CITY OF ALBUQUERQUE

August 31, 2016

**Re: East Gateway Dwelling Units
13400 Wenonah Dr NE
Traffic Circulation Layout
Architect's Stamp 07-13-16 (L22D033A1)**

SHEET TCL 1.0

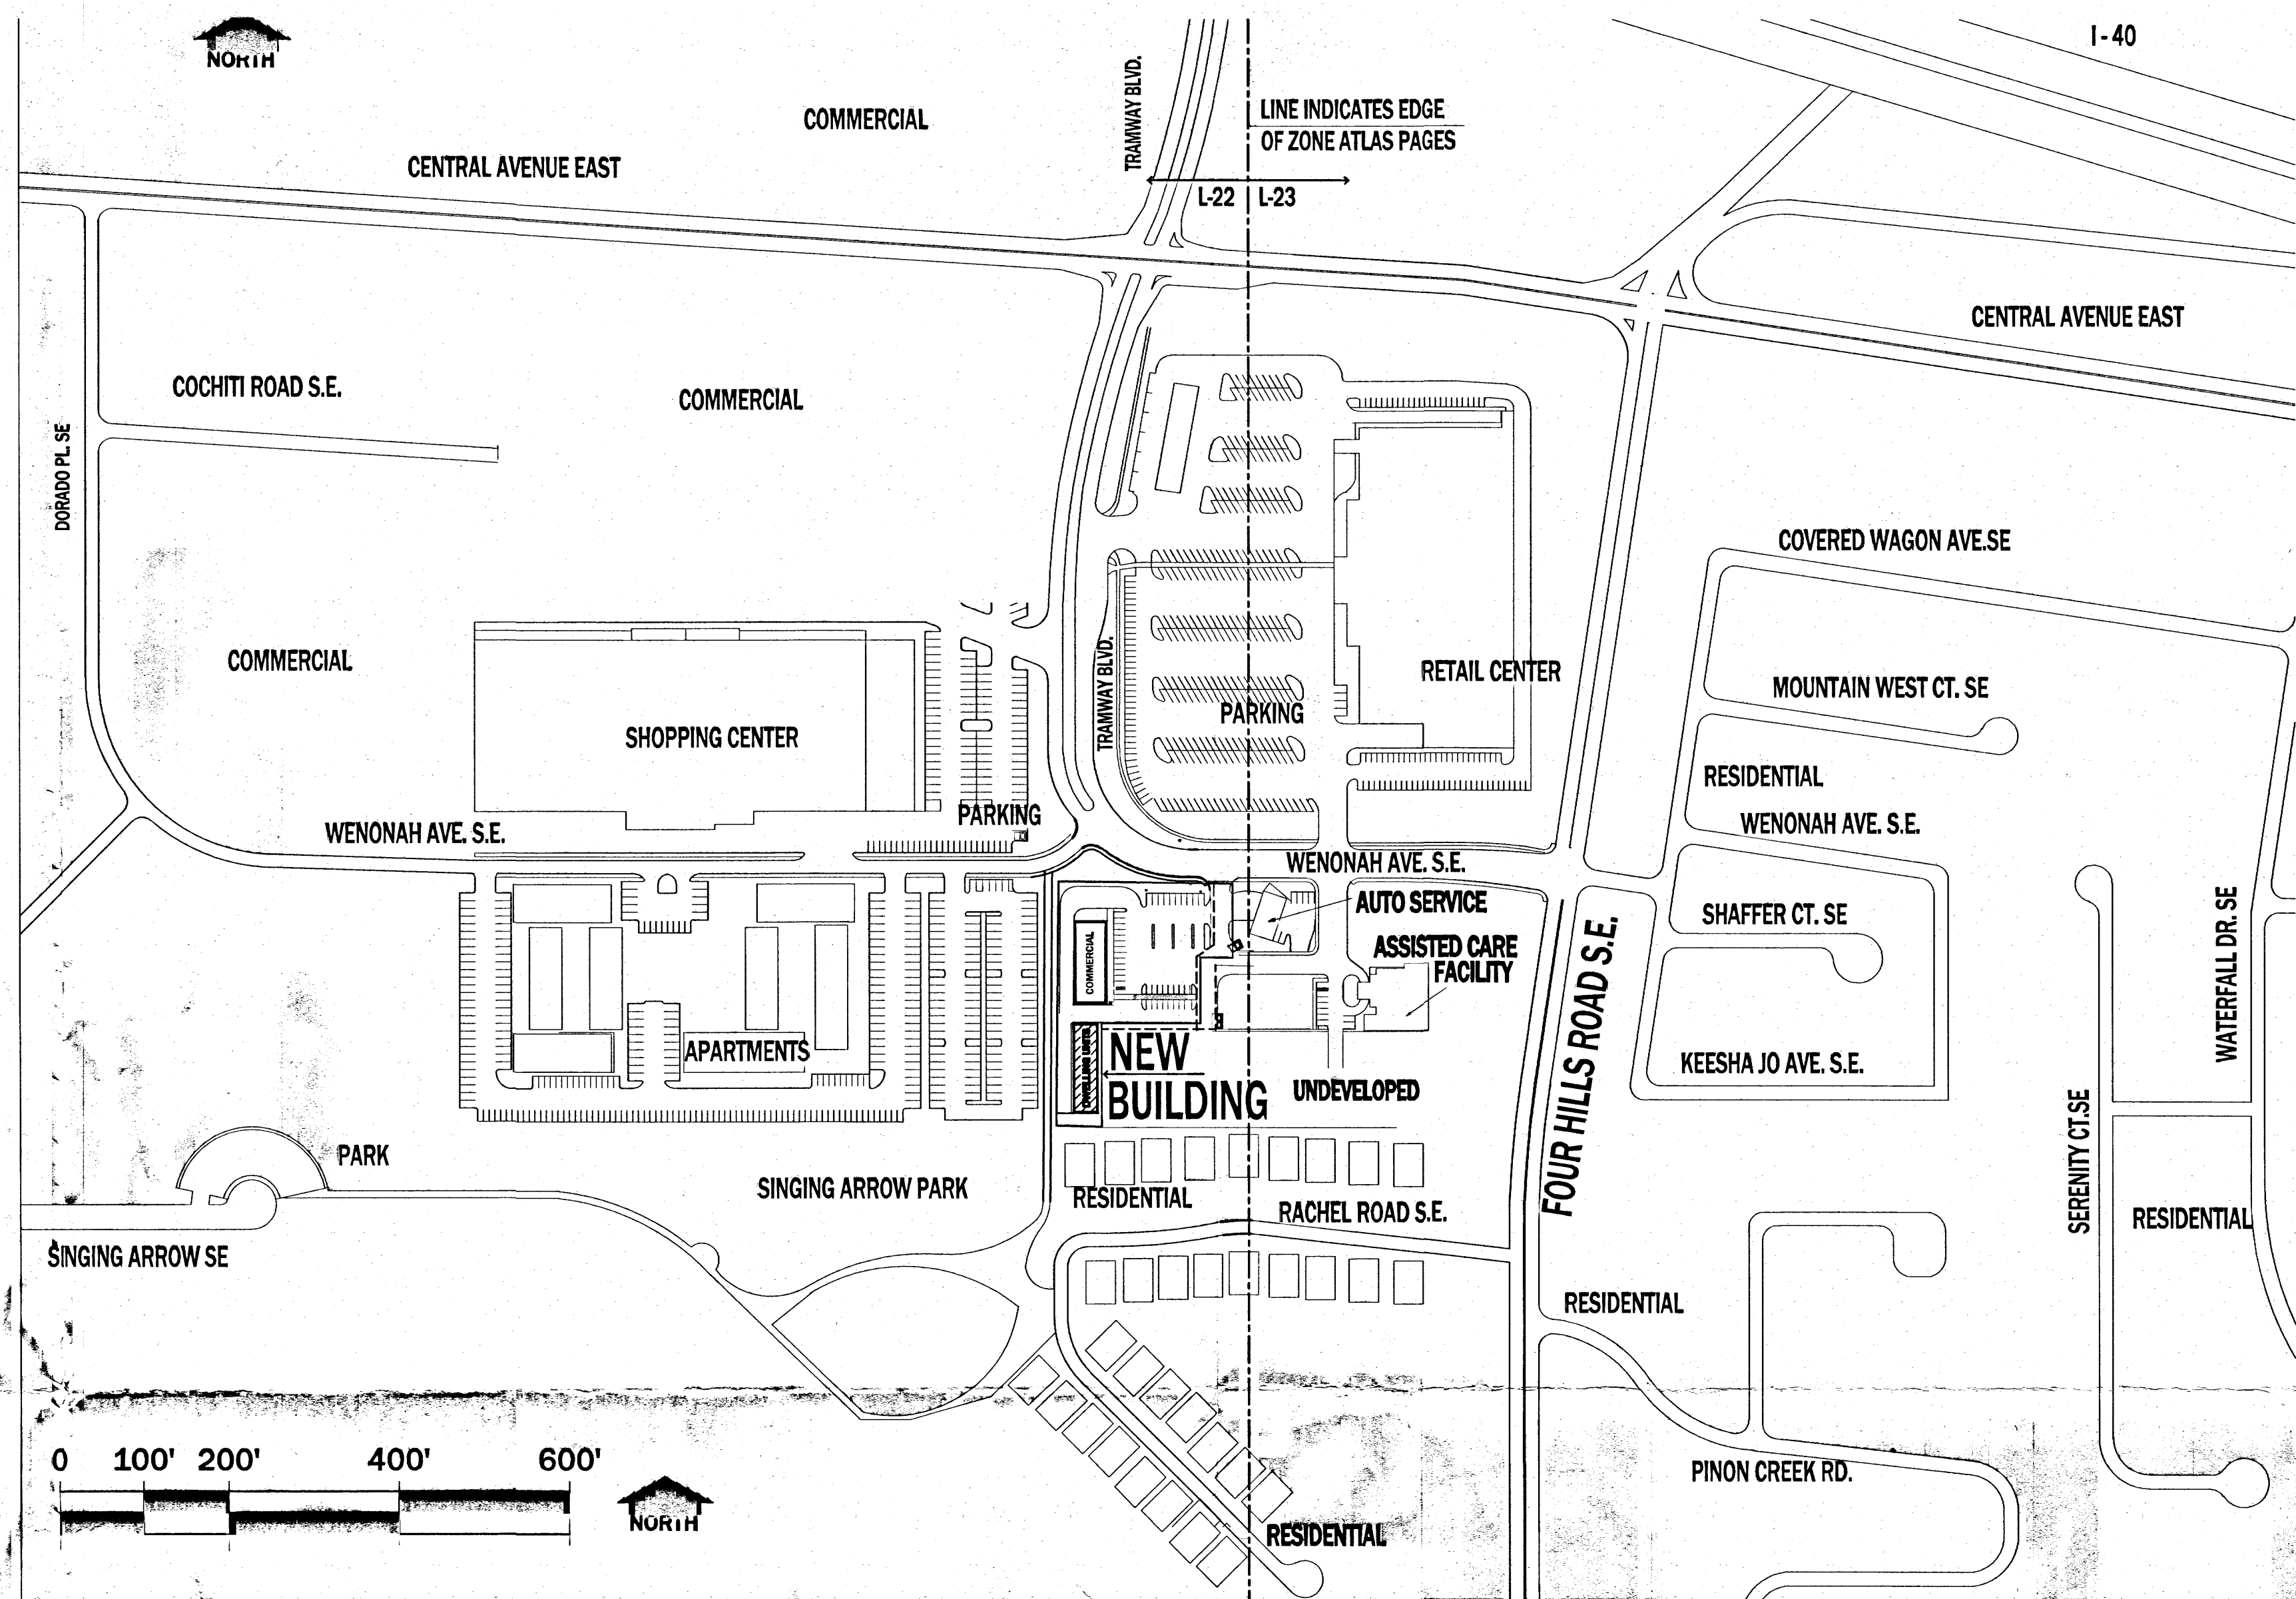
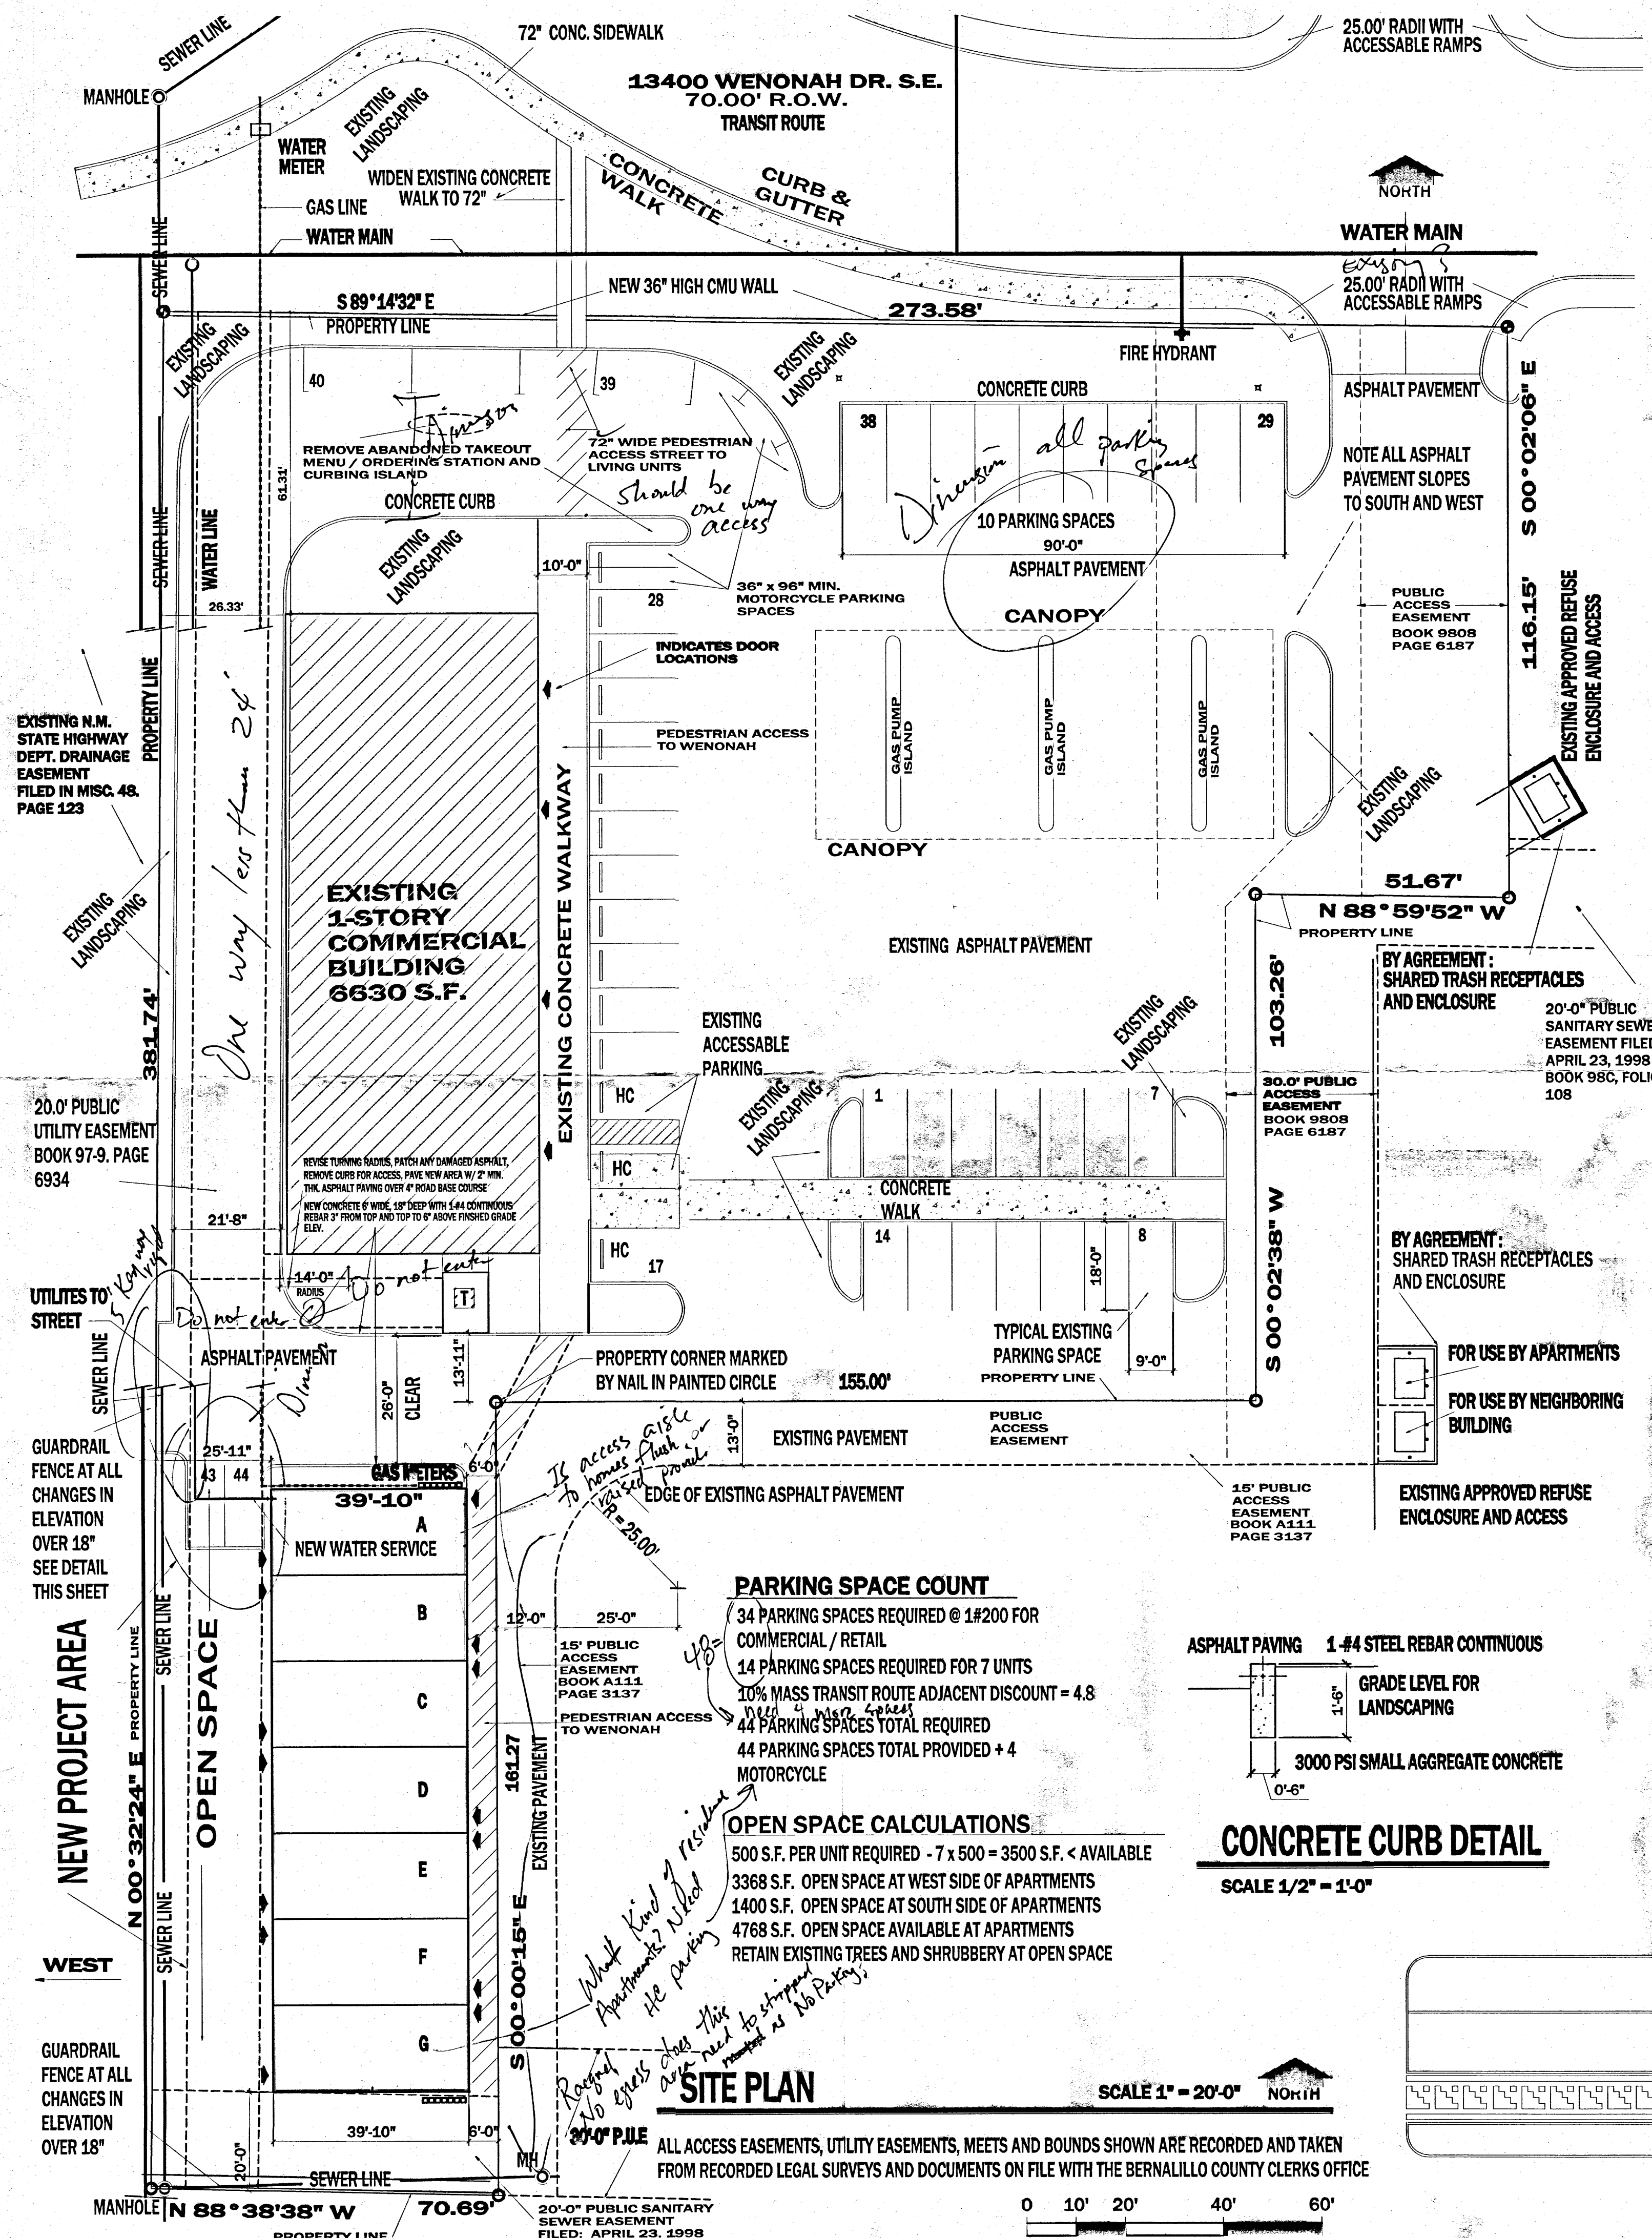
1. The number of parking spaces provided does not match the total required. Please provide number of ADA, motorcycle and bicycle parking required and provided for this site.

2. Identify the right of way width, medians, curb cuts, and street widths on Wenonah Ave.
3. Please list the width and length for all existing and proposed parking spaces. Some dimensions are not shown.

4. Motorcycle parking spaces must be visible to the entrance of the building.
5. A bicycle rack must be provided for the dwelling units.
6. The handicap accessible spaces must be a minimum of 8.5 ft. in width.

7. The handicap accessible spaces must include an access aisle. Van accessible aisles should be 8ft wide; all others should be 5ft wide.
8. The ADA accessible parking sign must have the required language per 66-7-352.4C NMSA 1978 **"Violators Are Subject to a Fine and/or Towing."** Please call out detail and location of HC signs.

9. The ADA access aisles shall have the words **"NO PARKING"** in capital letters, each of which shall be at least one foot high and at least two inches wide, placed at the rear of the parking space so as to be close to where an adjacent vehicle's rear tire would be placed. (66-1-4.1.B NMSA 1978)

10. Provide detail including dimensions for pedestrian and vehicular access to the dwelling units.
11. A 5 ft. keyway is required for dead-end parking aisles.

12. Provide a min 6" or max 8" high concrete barrier curb or other acceptable barrier between landscaping and parking areas and/or drive aisles. Please call out detail and location of barrier curb.

13. Dimension the drive aisle on the north side of the existing building from the perpendicular parking spaces to the concrete curb.
14. All drive aisle less than 24' may only be used at one-way access.

15. One-way vehicular paths require pavement directional signage and a posted "Do Not Enter" sign at the point of egress. Please show detail and location of posted signs.

16. Show the clear sight triangle and add the following note to the plan:
"Landscaping and signage will not interfere with clear sight requirements. Therefore, signs, walls, trees, and shrubbery between 3 and 8 feet tall (as measured from the gutter pan) will not be acceptable in the clear sight triangle.

17. Please specify the City Standard Drawing Number when applicable.
18. Please include a copy of your shared access agreement with the adjacent property owner.

19. Add a note stating "All broken or cracked sidewalk must be replaced with sidewalk and curb & gutter." A build note must be provided referring to the appropriate City Standard drawing.
